REVISION RESPONSE LETTER

**RE: Claremont Business Park 2 Filing 1, Lot 5
Site Development Plan
File Number PPR2030**

DATE: December 3, 2020

GRADING & EROSION CONTROL PLAN  
CLAREMONT BUSINESS PARK 2 FIL. NO. 1 - LOT 5  
JOB NO. 44-037  
DATE PREPARED: JULY 17, 2020  
DATE REVISED: OCT 27, 2020

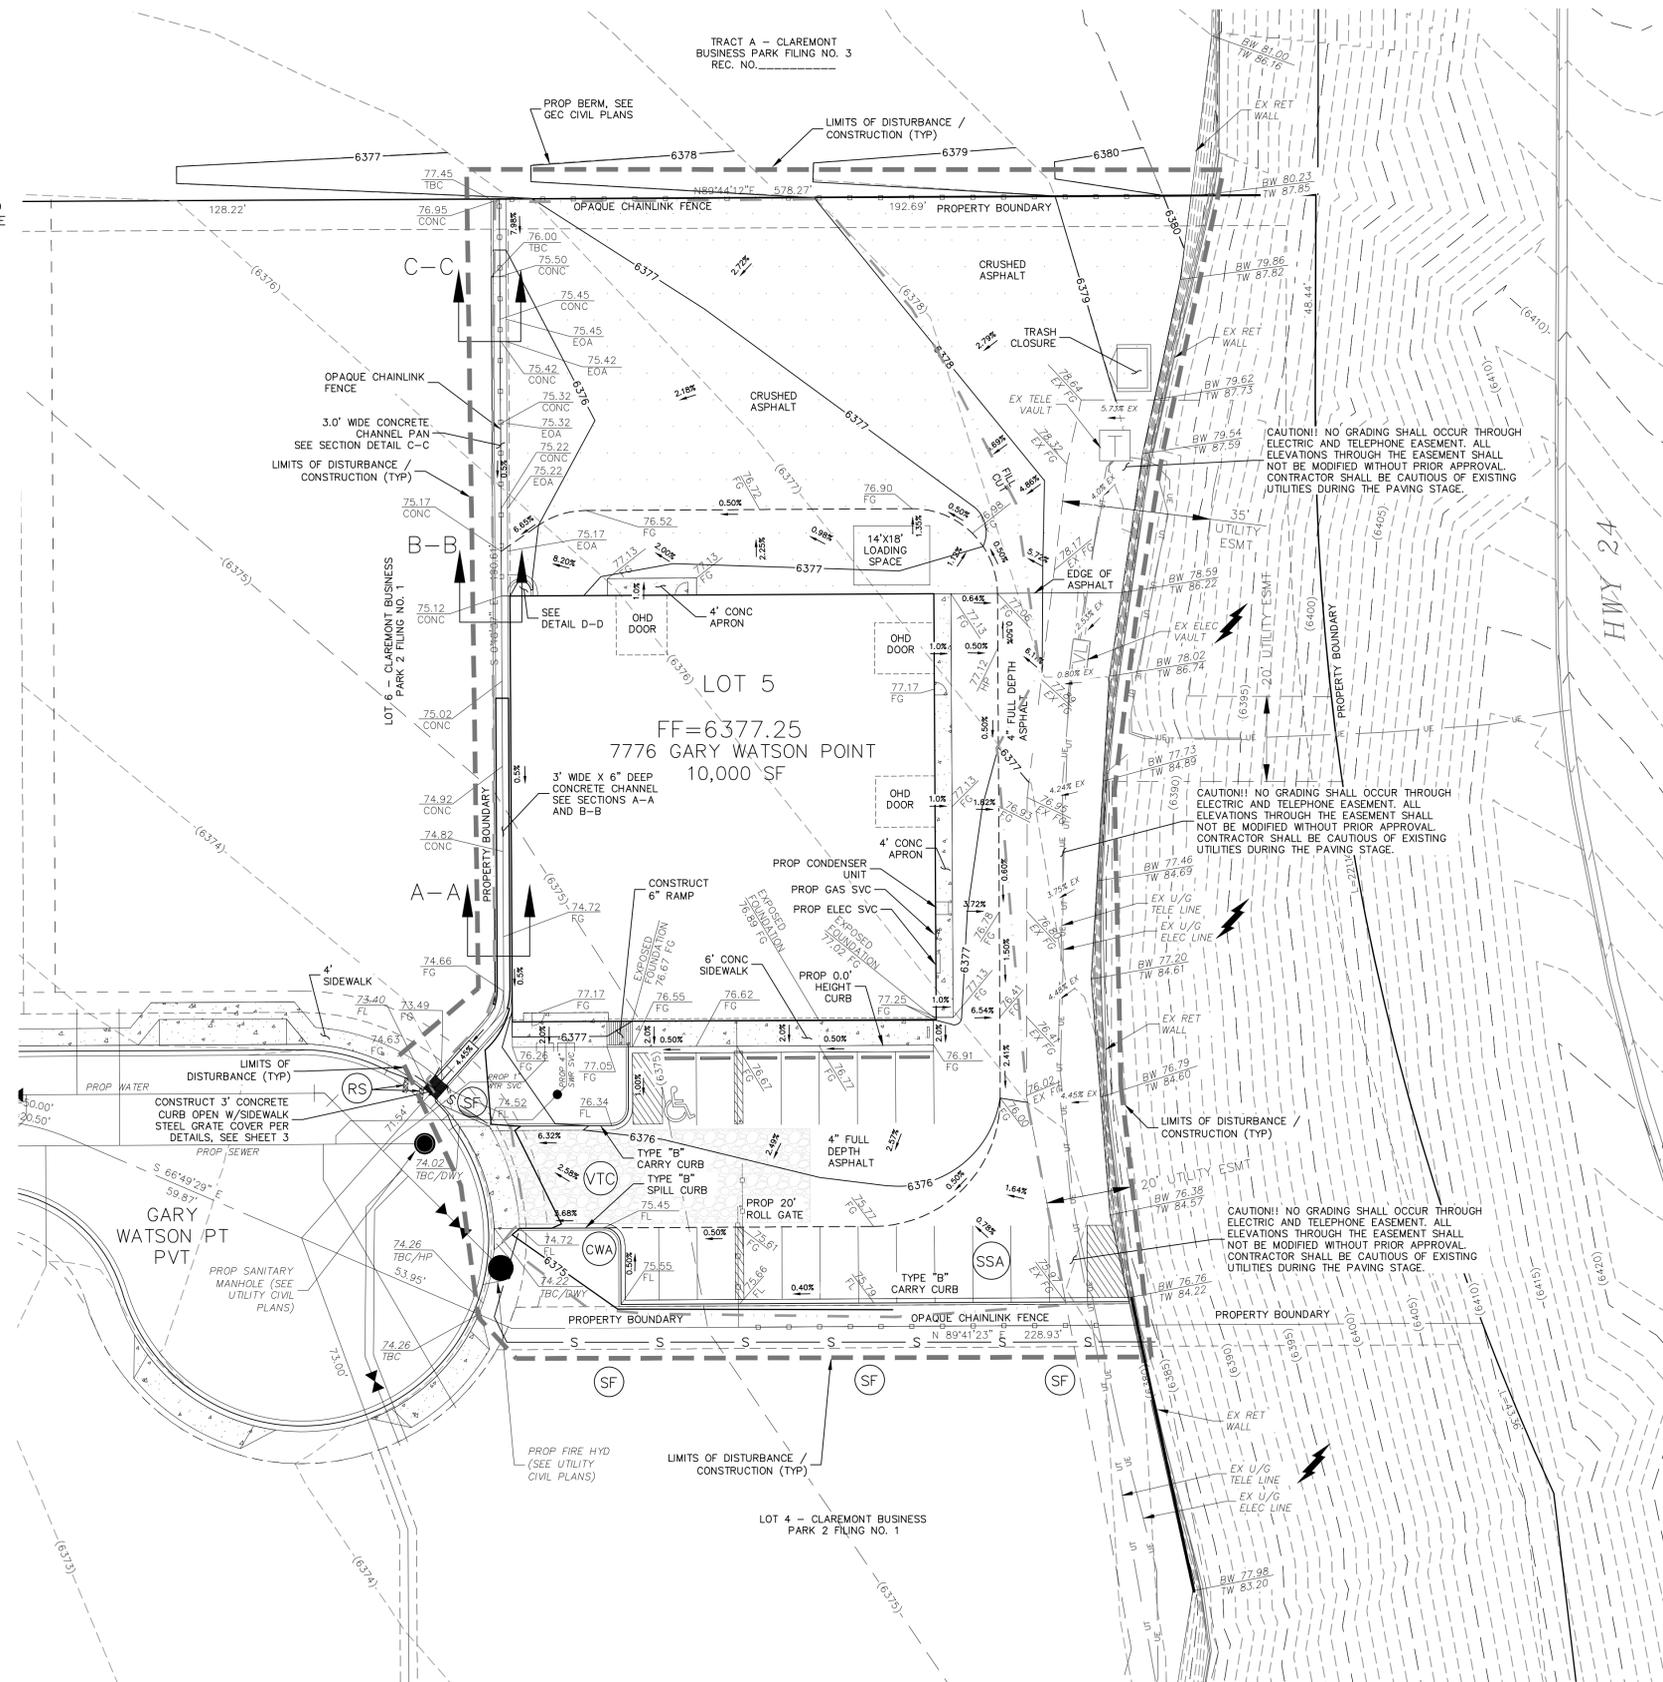
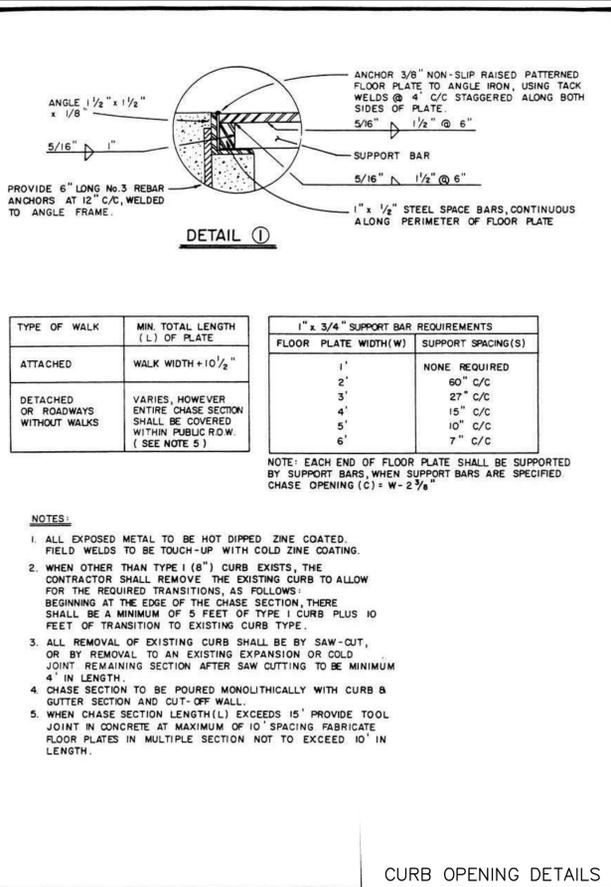
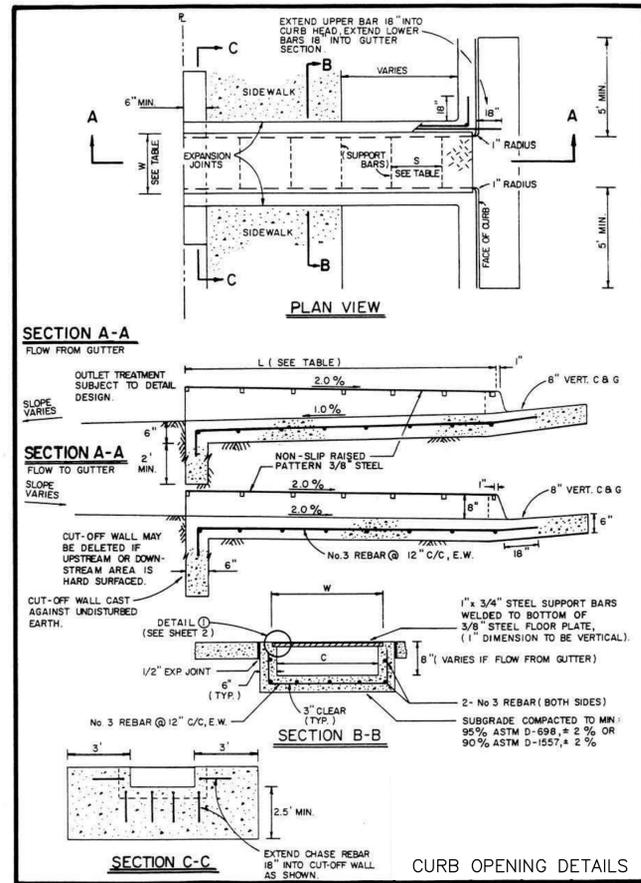
1. *Show existing and proposed topography.* **Existing and proposed topography is shown on the Grading & Erosion Control Plan from M&S Civil Consultants, Inc., included in the original submission of this Site Development package. Per the Planning and Development website, “A Site Plan is an accurately scaled drawing of a lot or parcel showing, at a minimum, the property address, the schedule/tax number, all existing structures, easements, rights-of-way, setbacks from the property lines to the existing structures (if any), the location of the lot in relation to abutting streets, driveway/access location(s), and dimensions of the proposed structure and of existing structures, including height.” We feel to clearly show the intent of our site layout, by keeping the plans as clean as possible to maintain the required information, the grading contours should remain off, shown on the grading plan as it is part of site development package. In addition, we try to ensure accuracy, and not be held liable, by not duplicating information that may not be carried over from outside sources, i.e., civil engineering plans. Furthermore, we have been doing plans in EPC for 20 years and this comment has never come up before. As mentioned above, we would prefer to keep the grading off of the site plan to maintain consistency, accuracy and cleanliness.**

## EL PASO COUNTY, STATE OF COLORADO UTILITY SERVICE PLAN

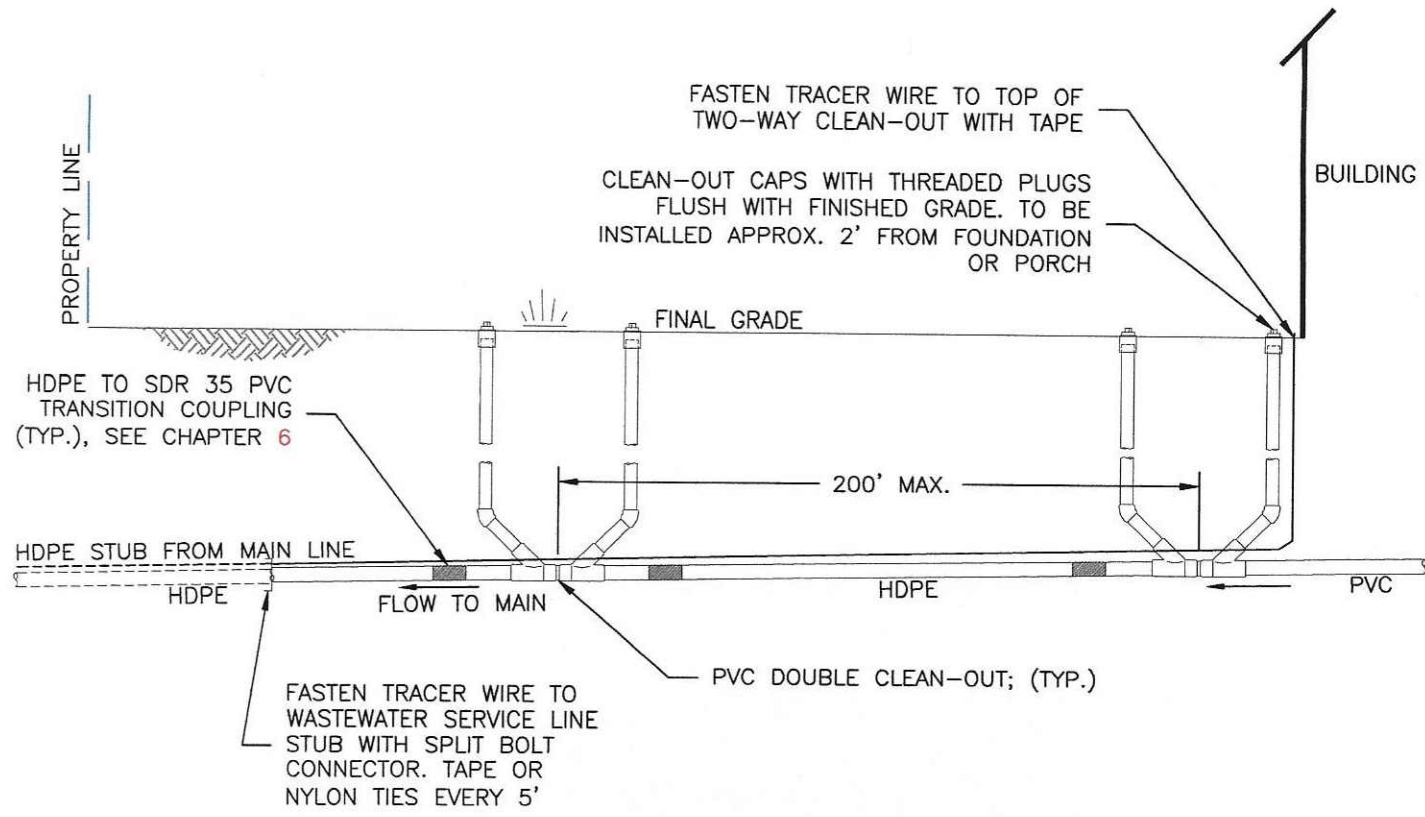
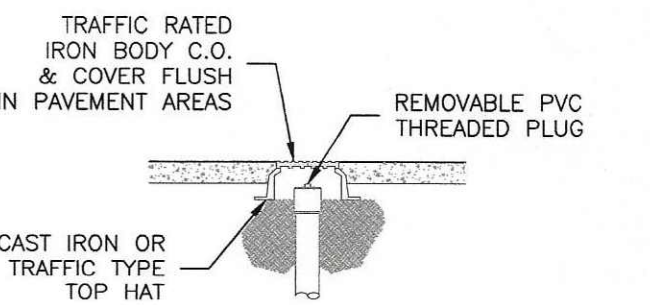
2. *Show the location of all existing and proposed utilities on the site or in the adjacent ROW to include all easements.* **Please refer to our response in comment no. 2. We feel this is not needed as utilities tend to change in the field and we don’t want to have an approved document to show these discrepancies. In addition, our civil engineer coordinates this design and ensures no issues with the placement of utility services per our design. Furthermore, EPC does not stamp the utility plan.**
